Our ref: SSD-7709-PA-55

**Moorebank Precinct West Stage 2 (SSD 7709)  
Road Safety Audit – Condition B112**

I refer to the Road Safety Audit report, dated 16 July 2020, prepared by an independent Transport for NSW accredited road safety auditor (ARRB) under the conditions of consent B111 of SSD 7709.

ALL TRANSVERSE LINEMARKING, PAVEMENT ARROWS AND CHEVRONS TO BE MARKED USING THERMOPLASTIC.

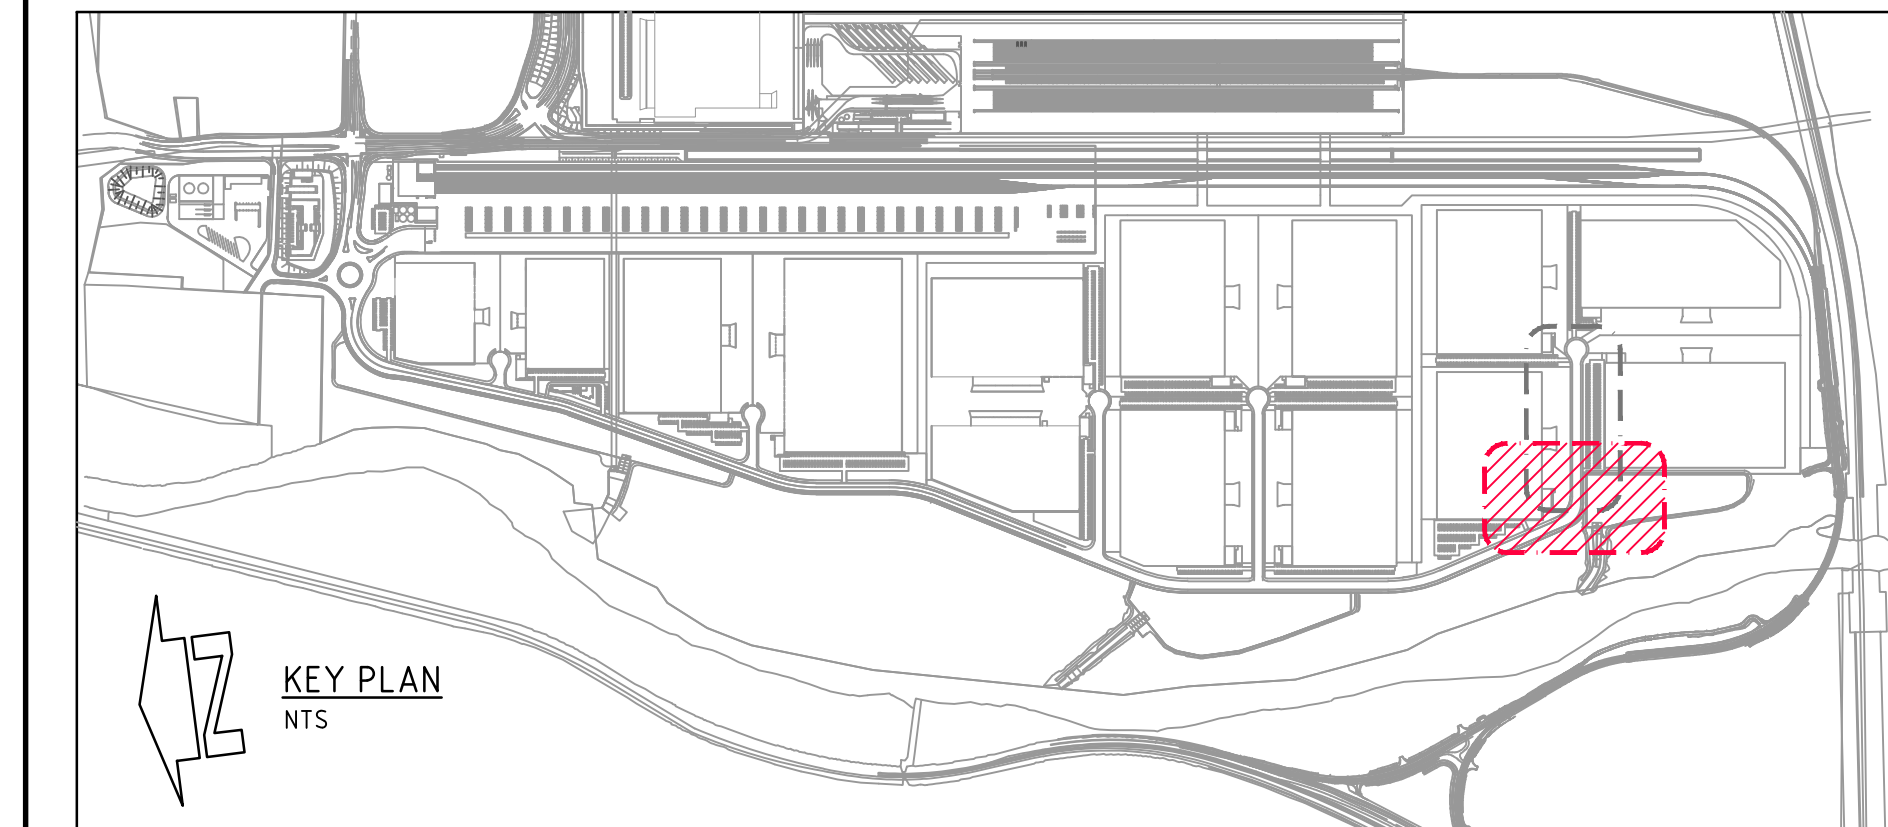
I note that the audit suggests increasing the timing for pedestrian/cyclist crossing phases by delaying the green turning arrow for motorists at the Chatham Avenue / Moorebank Avenue intersection.

In your correspondence dated 12 October 2020, you advised the Department that no corrective action will be taken due to a lack of pedestrian connectivity south of this intersection.
